City of Albuquerque Stormwater Construction Site Inspection Report

ESC File No.	D18E009A	Project Name:	Hope Christian Elementary School		
NPDES Id. No.	NMR1002NC	Location:	6801 Palomas		
7/7/2021	Owner	Contractor			
Operator	Hope Christian School	PWKI			
Contact name & title	Ieresa Groom	Adam Kenderdine			
e-mail	tkgroom@hcsnm.org	adam@pwki.com			
Contact Phone #	505-821-2513	505-908-5066			
COA Inspector	Thomas Evans	Start/End Time:	8:55 AM-9:05 AM		
Construction Phase:	Stabilization				
Type of Inspection:	Regular	Storm Event	Past Storm Event >0.25"	311/Complaint	Follow Up
Weather at time of inspection?	Clear		Temperature: ~	81	
Estimated date of last storm 0.25" or greater	7/6/2021

1 EROSION AND SEDIMENT CONTROL -
PROPOSED CONDITIONS
1" = 30'-0"

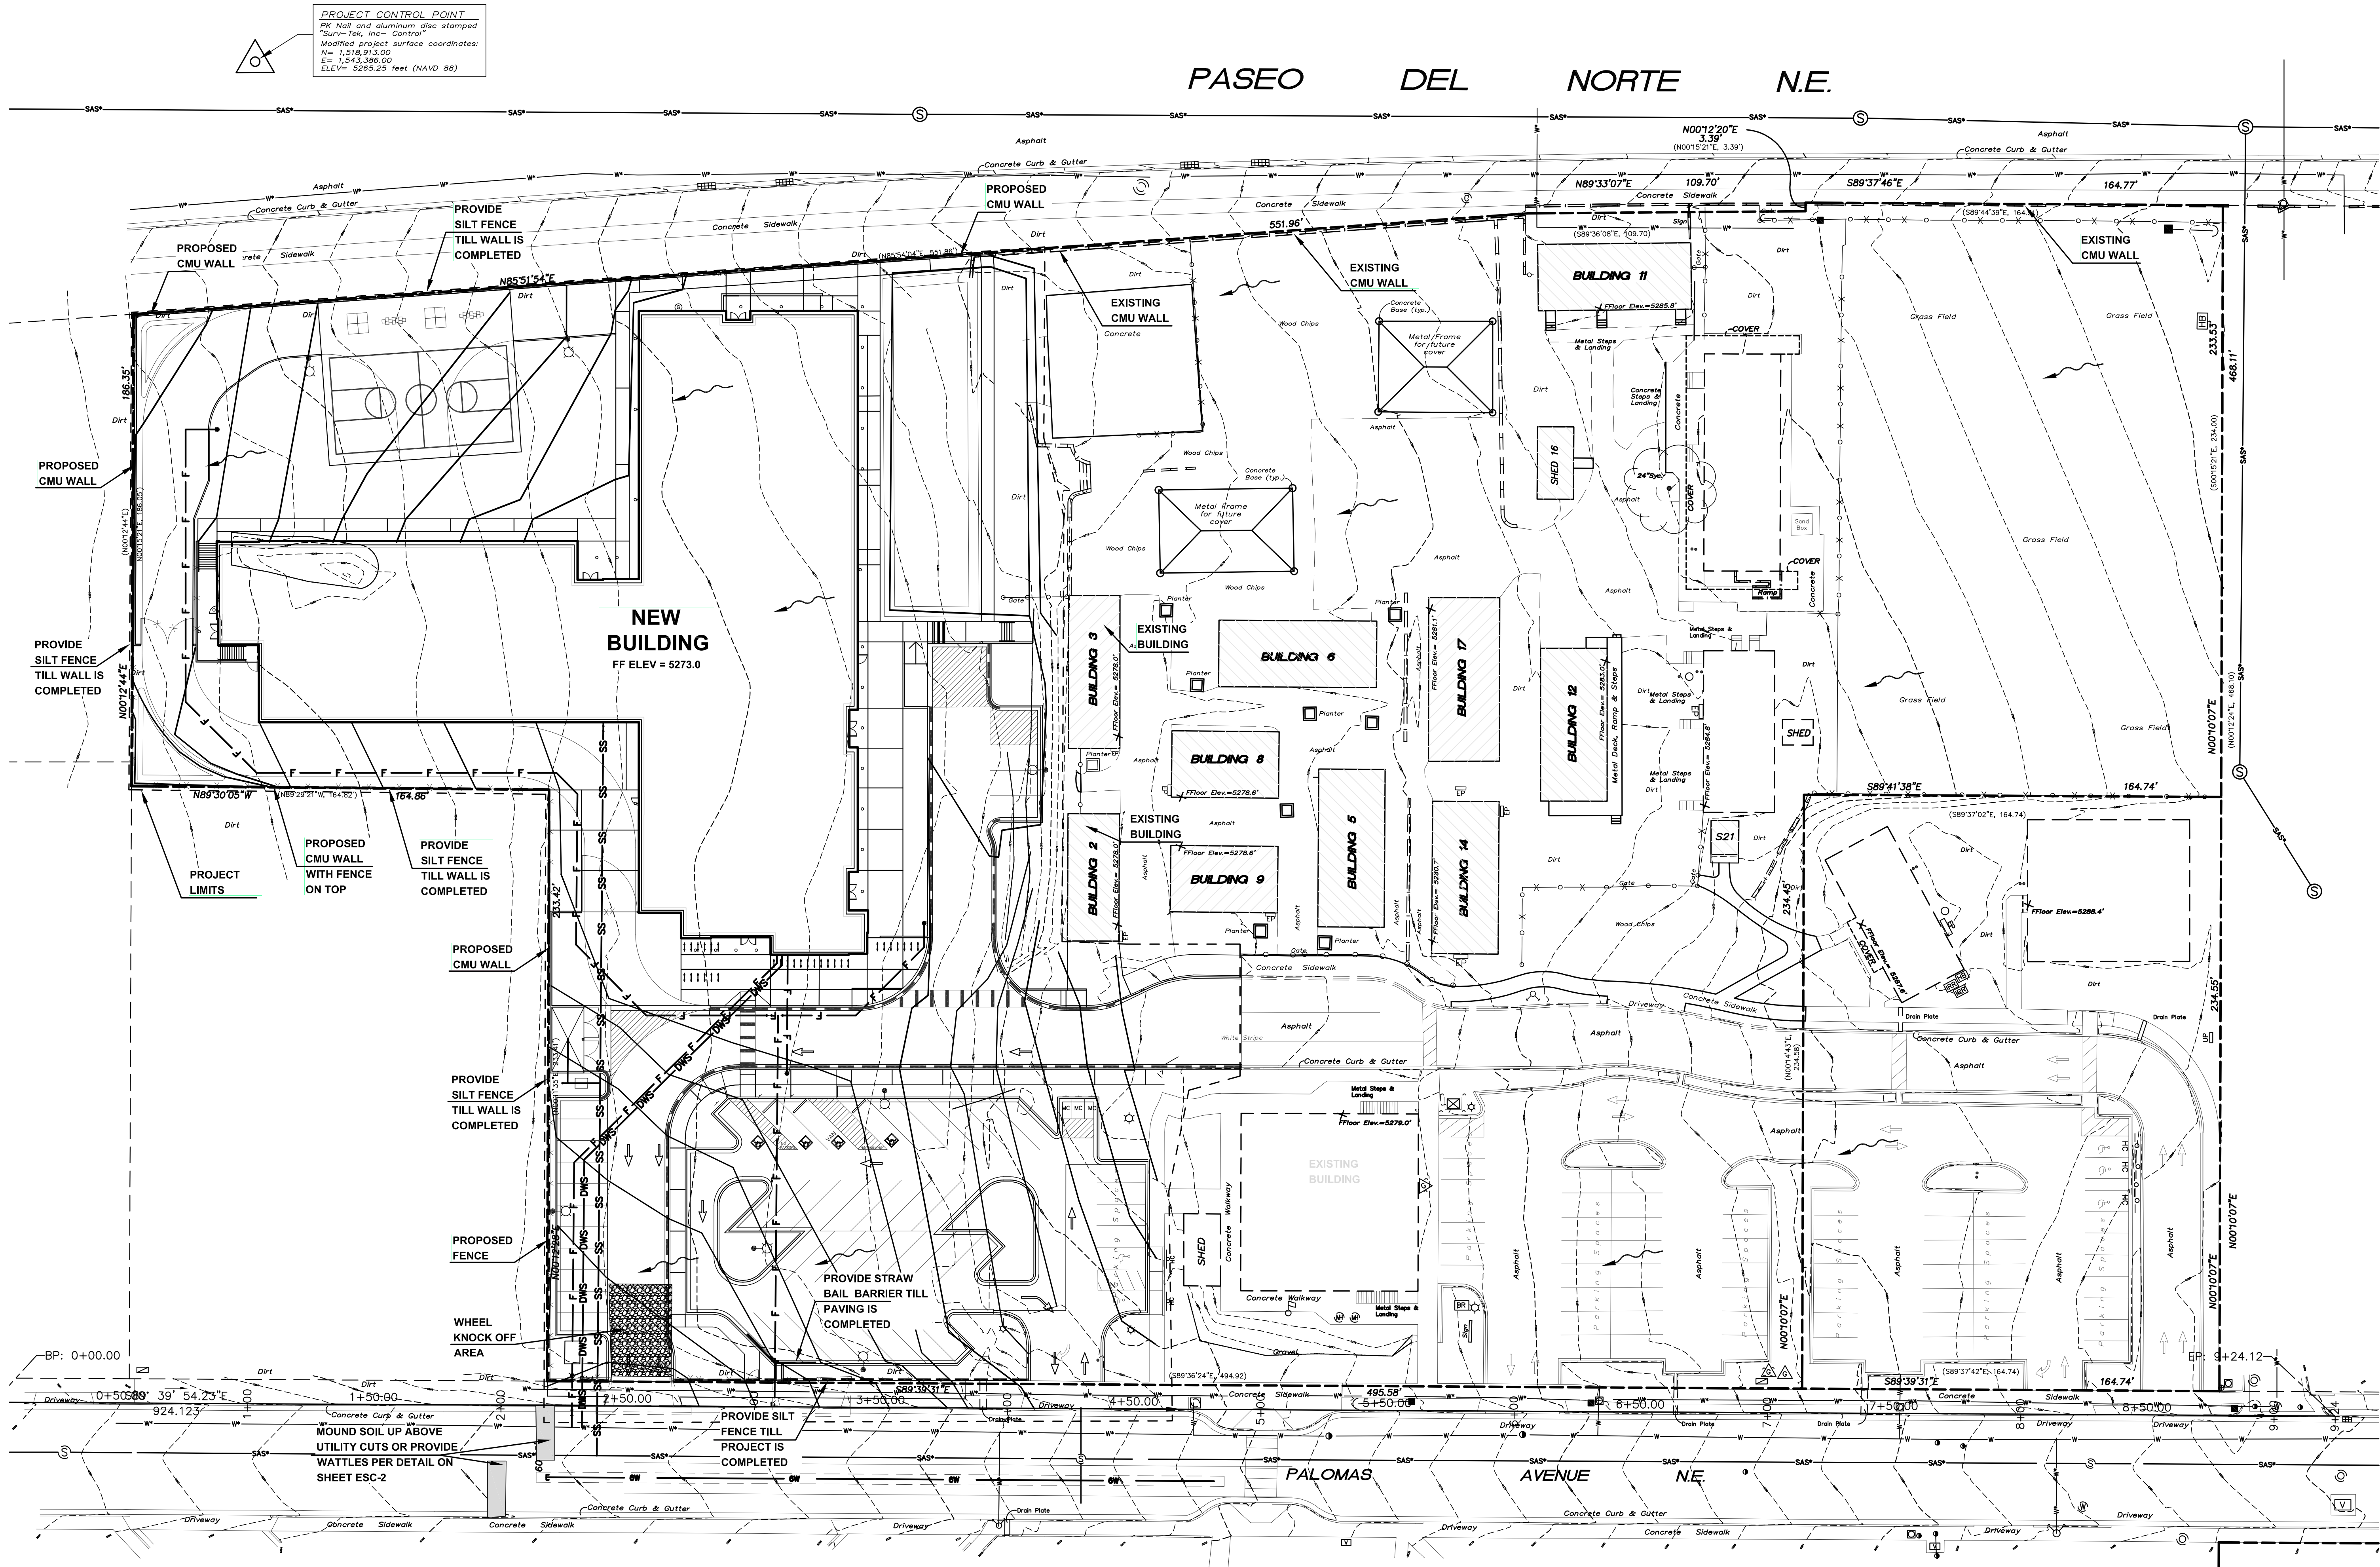
Item Number	Deficiency/ Corrective Action				
1	Areas not stabilized on North side. Sediment is washing out on to the concrete pad. Need to stabilize this area per CGP 2.2.14.				
2					
3					
4					
5
